FW: Soakaway location BE/88/18/DOC

Further drainage comments

Comments Regarding Condition 3

Scale: 1:100 No. 1891-1-102 B

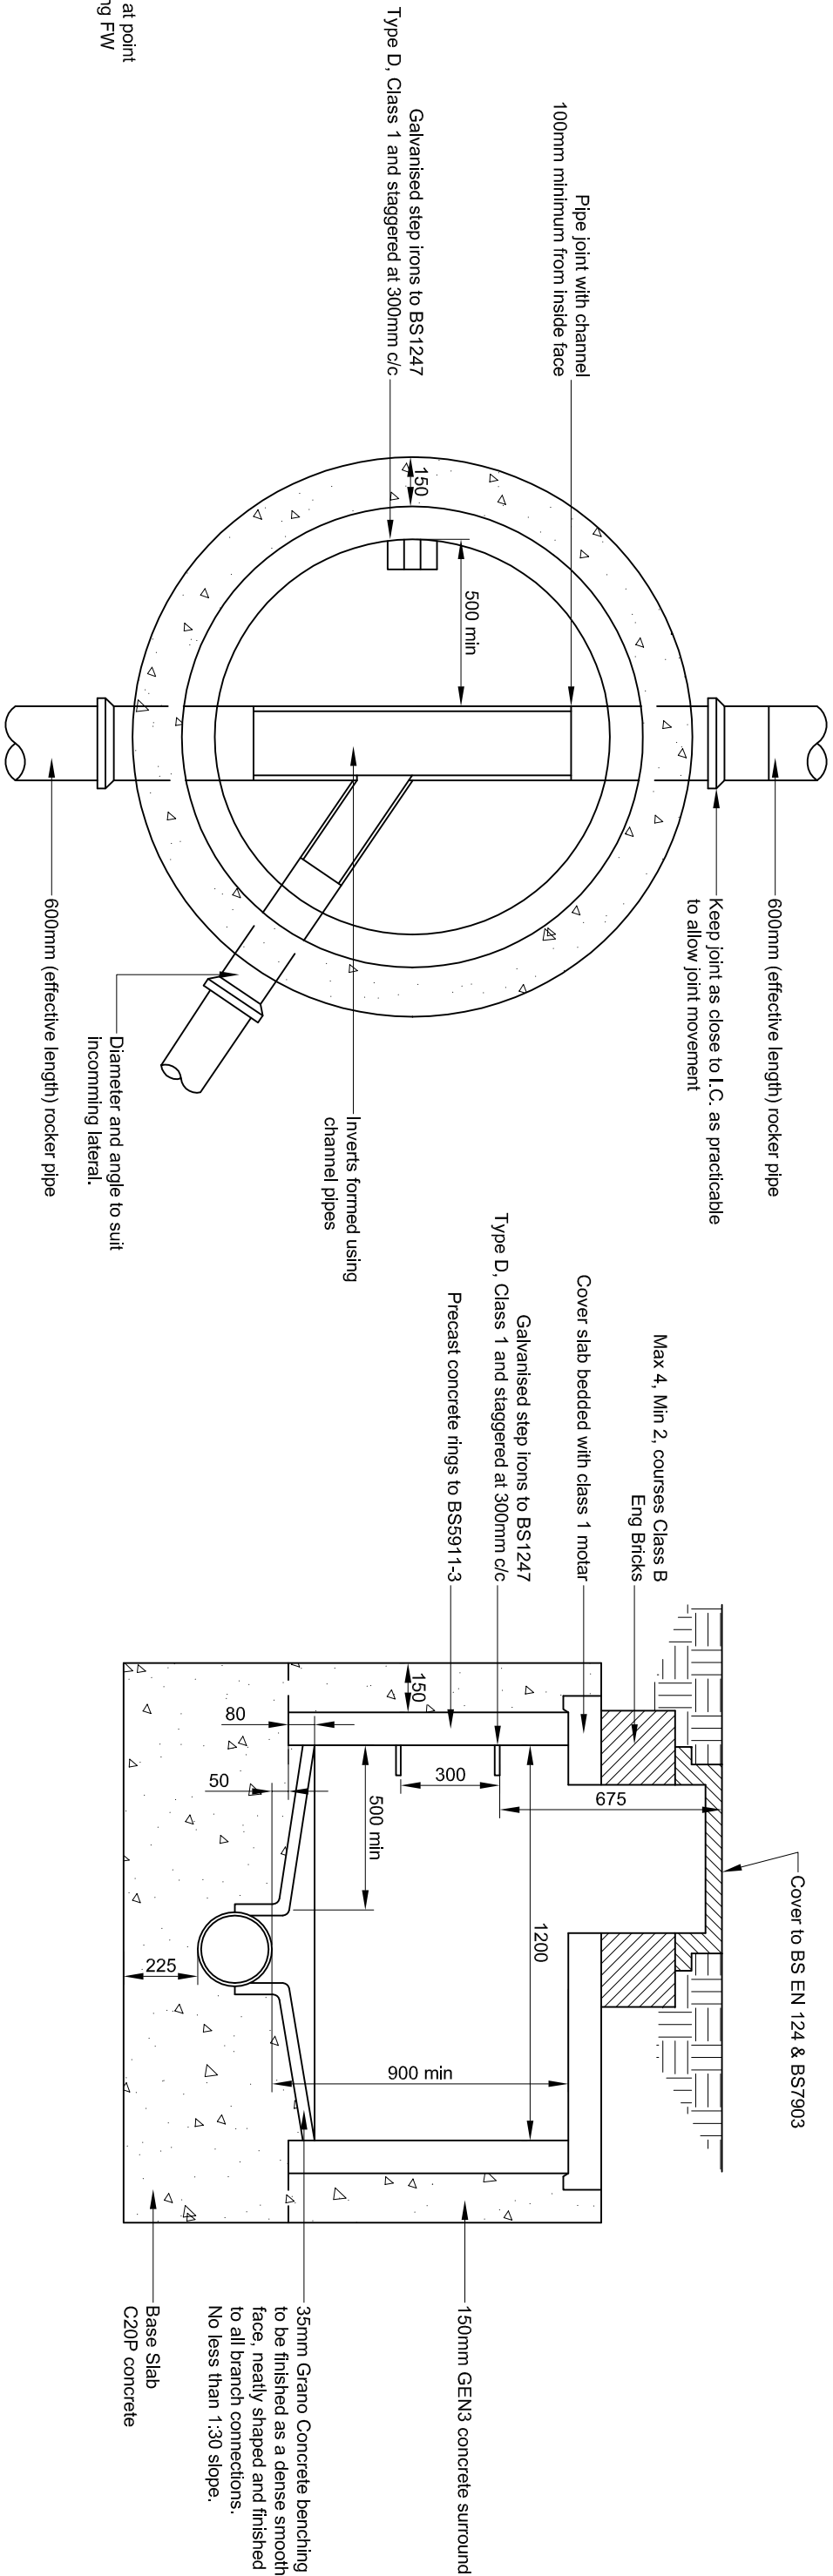
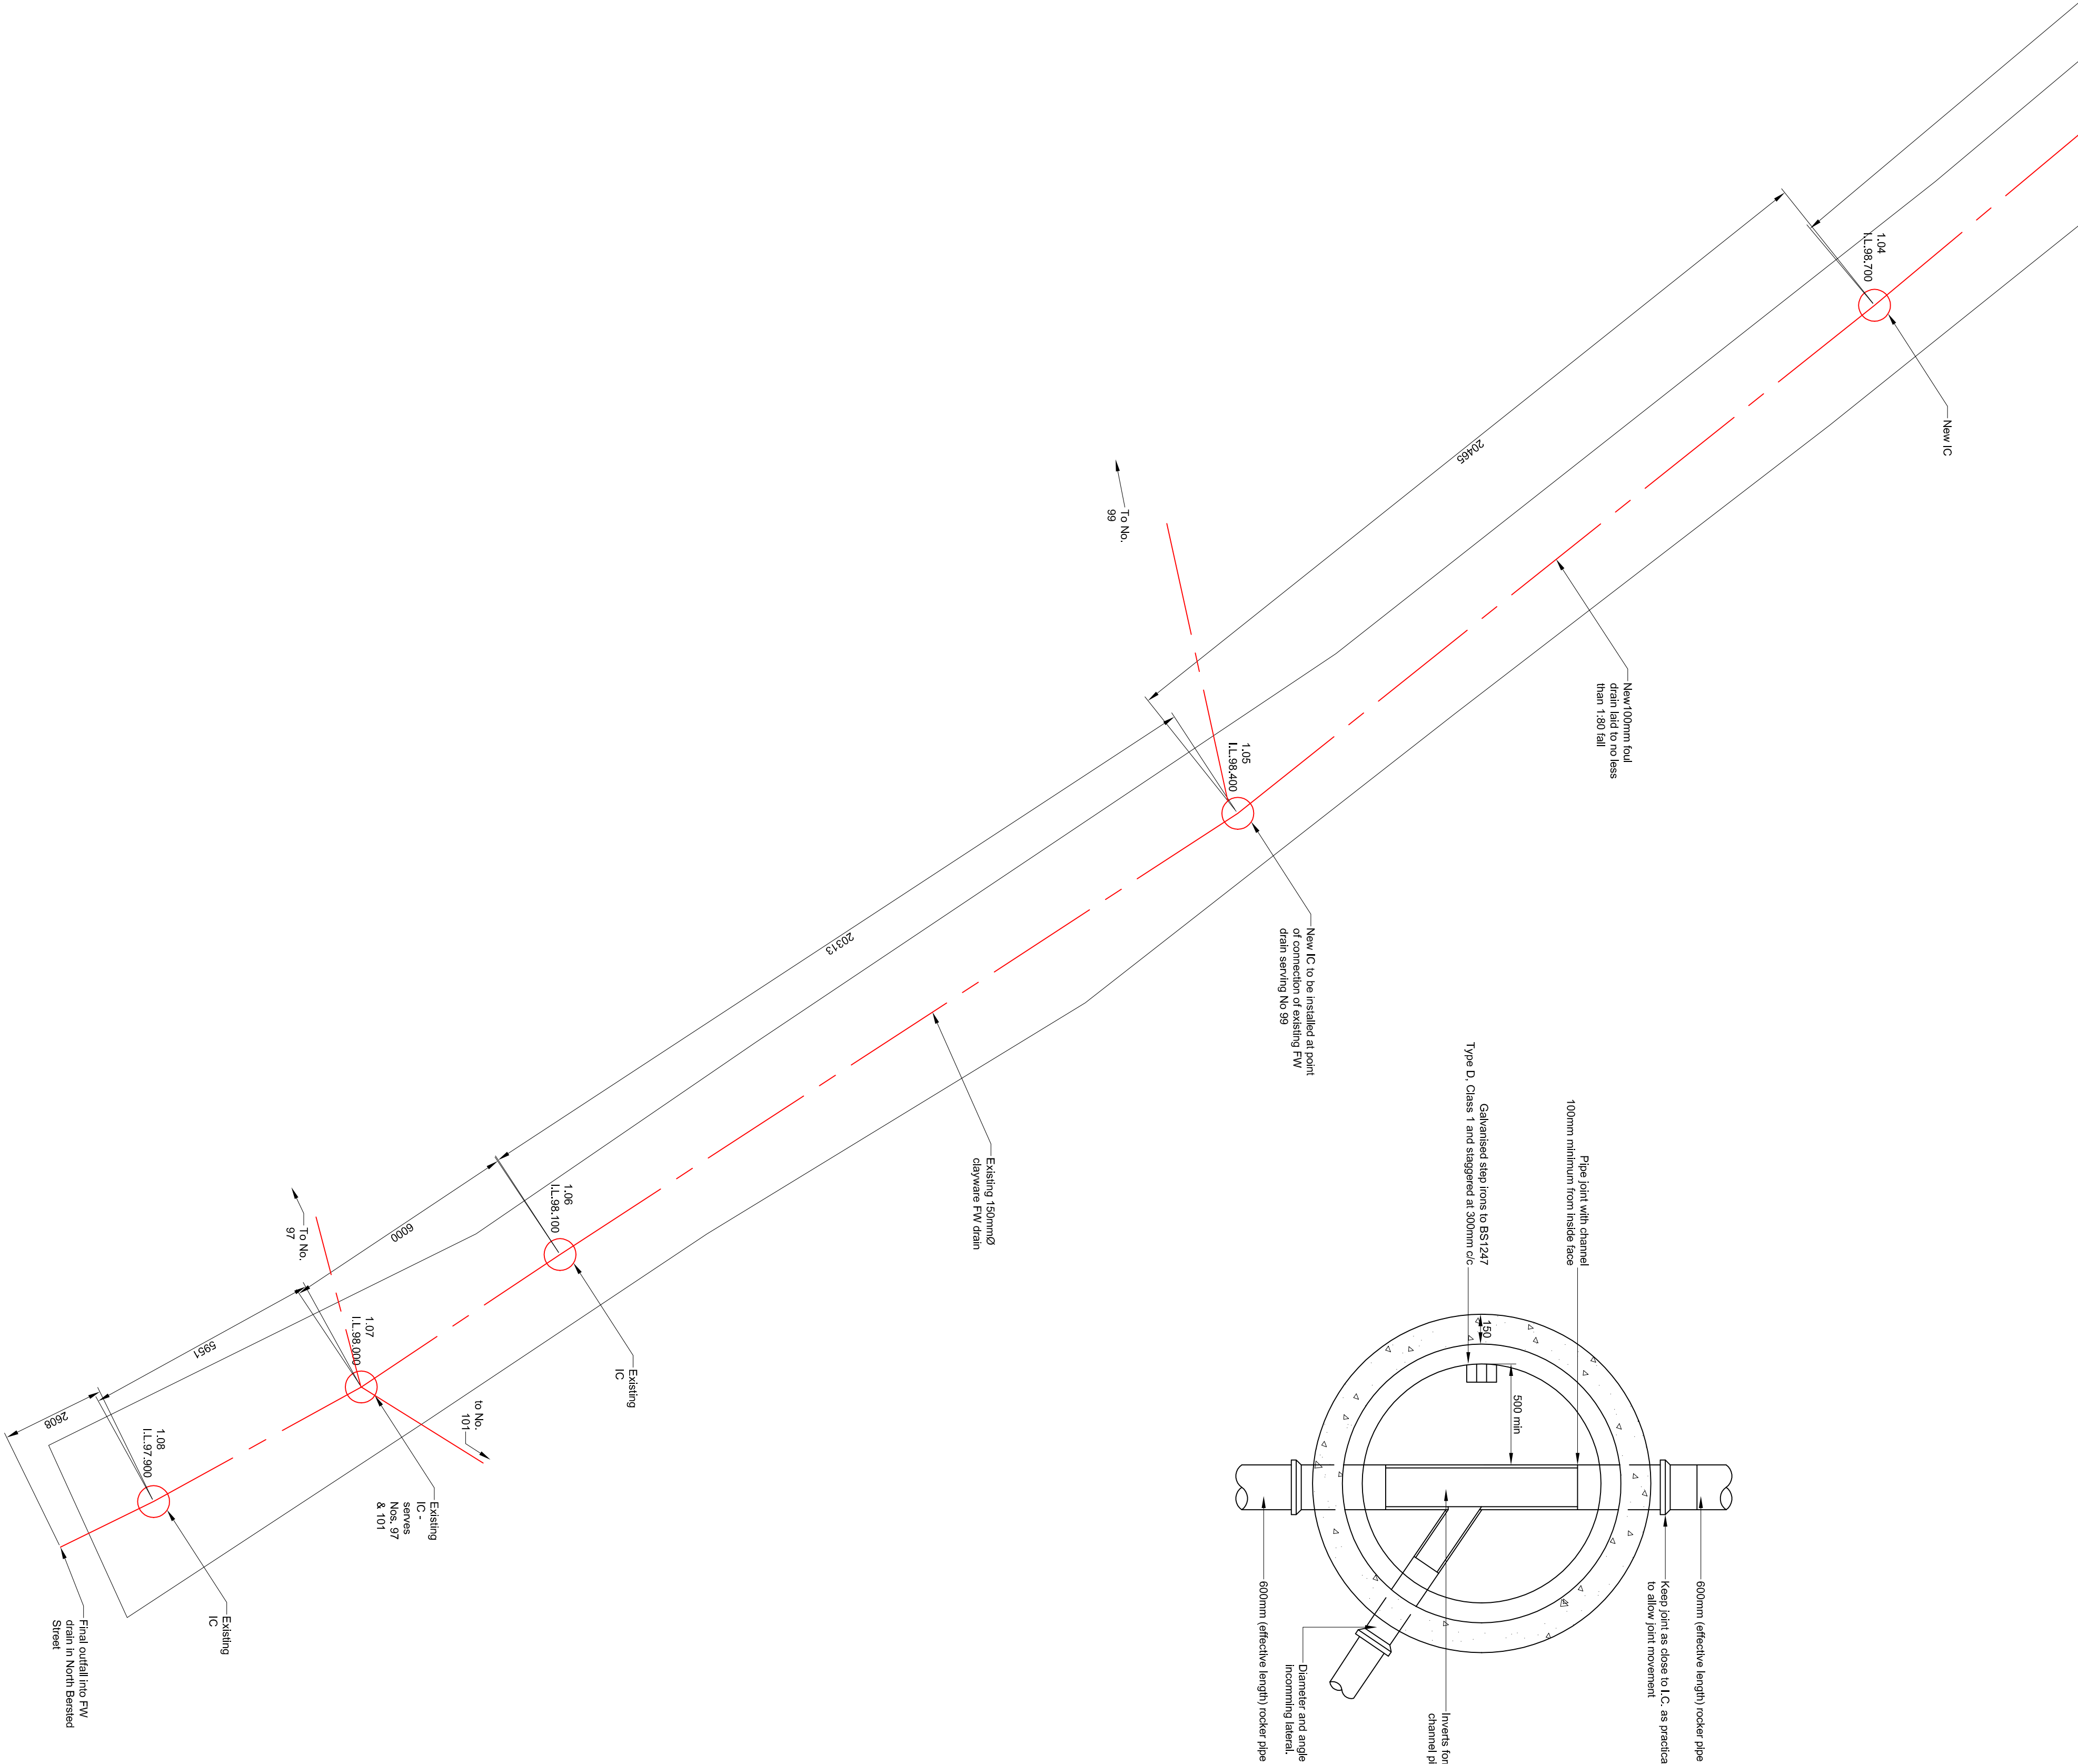
The soakaway depth and size is fine. However there are still some points which need to be rectified. The plastic pipe which connects from the down pipe to the soakaway needs to have concrete bed and surround. Also, a catchpit needs to be provided upstream of the soakaway.
